# COLORADO

Department of Transportation

August 28, 2018

RE: Flying Horse North Final Plat, Filing 1\_(SF181) (EA-17-019) (SF - Final Plat)

DESIGNED BY	PRA	SCALE	DATE	08-11-17																													
DRAWN BY	PRA	(H) 1"= 50'	SHEET	6 OF 58																													
CHECKED BY		(V) 1"= 5'	JOB NO.	1096.11

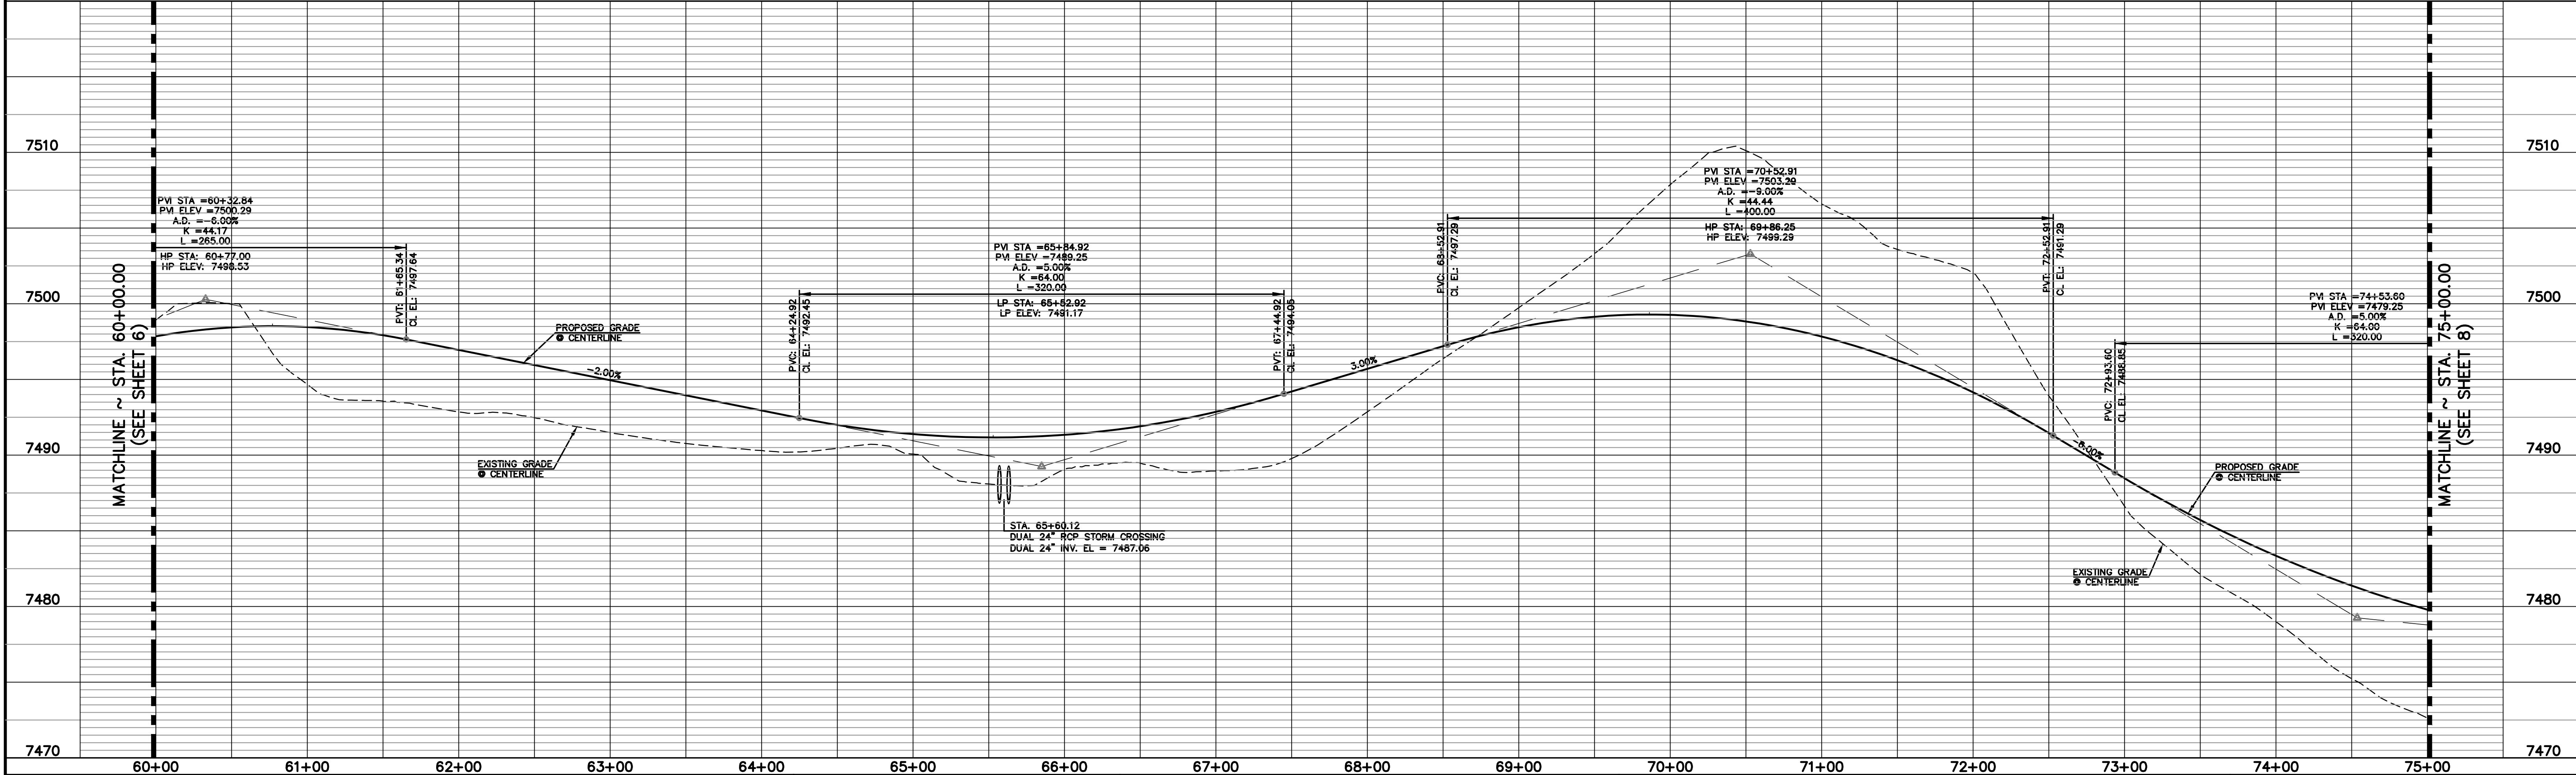
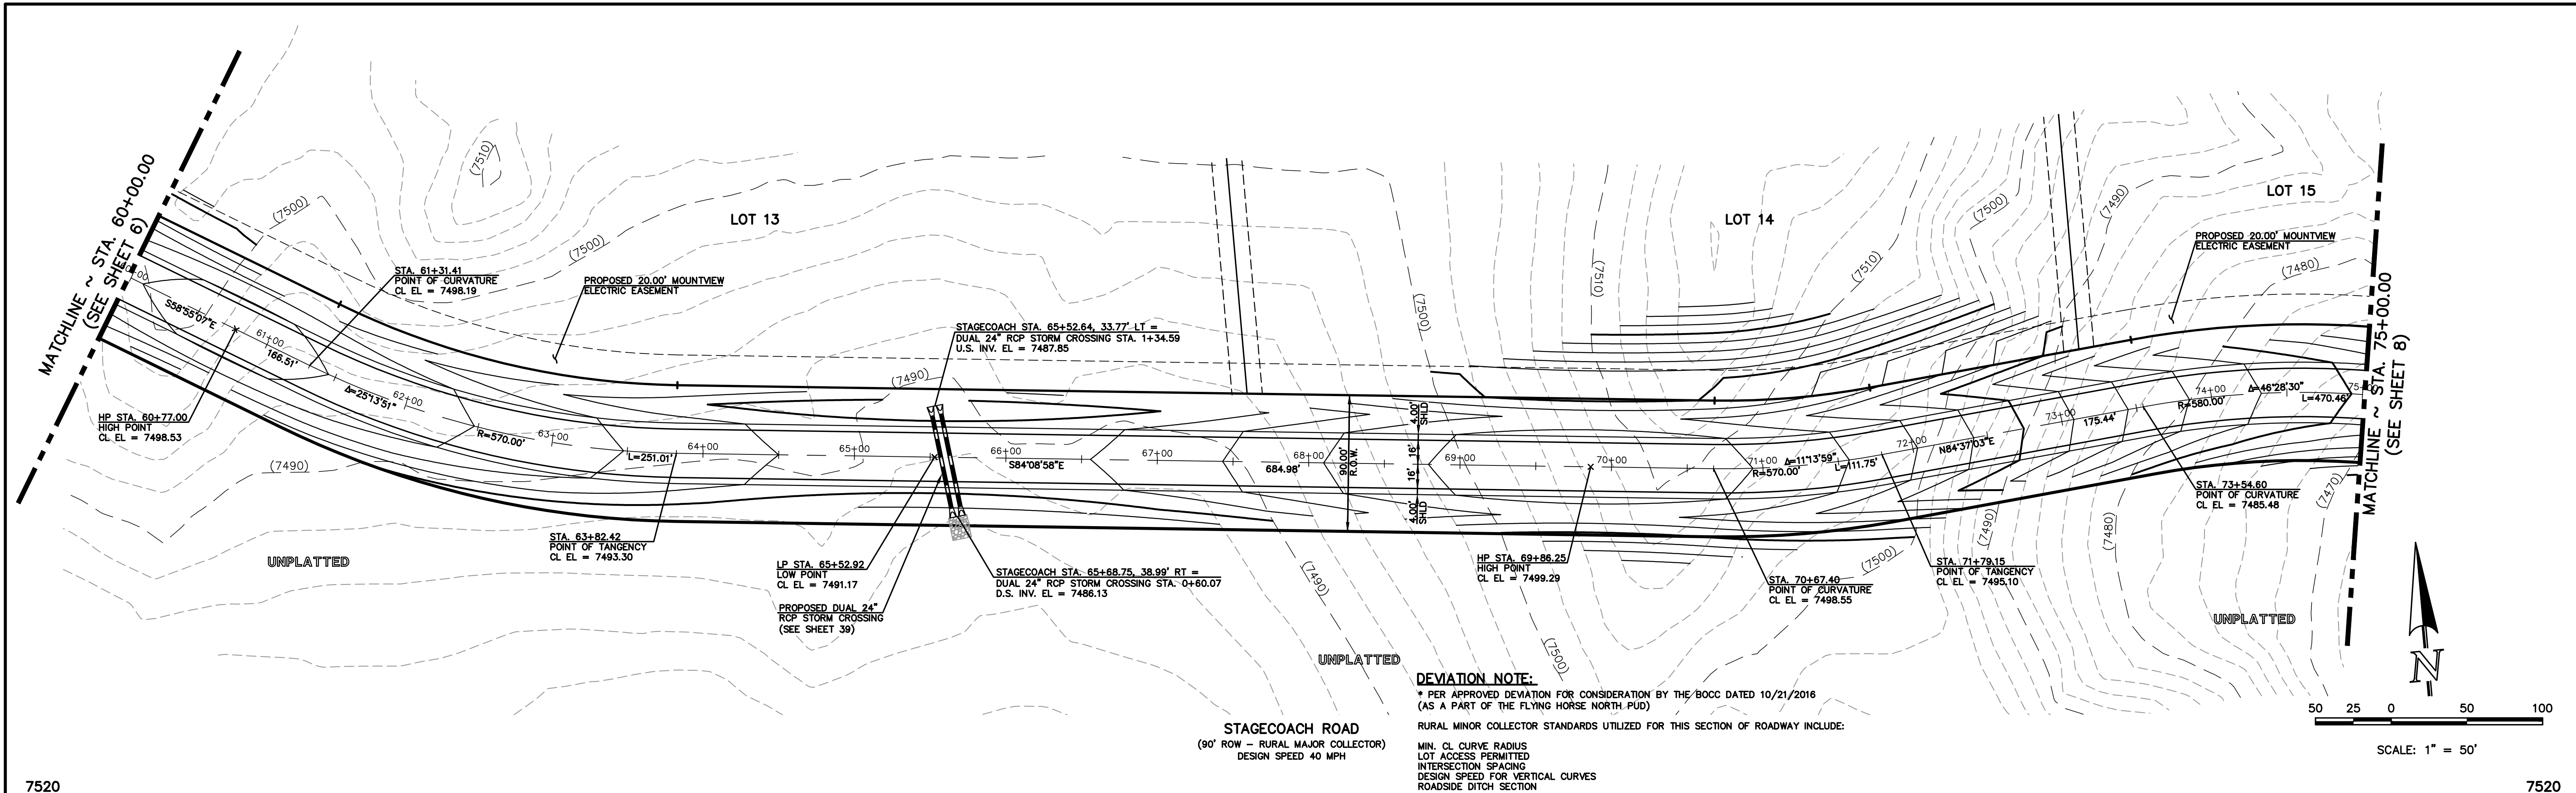
- Drainage comments: In regard to the roadway construction of SH83/Stagecoach
  - a. Do not have enough cover Run-4, Run-3 (Stagecoach), then Run-2 needs to be checked as well. The total pavement section is 17" and then 12" between top outside wall of pipe to bottom of pavement section.

- b. I am concerned about ditch details, ponding at intersection of Stagecoach and HWY 83, need more details on grading and how that all ties in and works there.
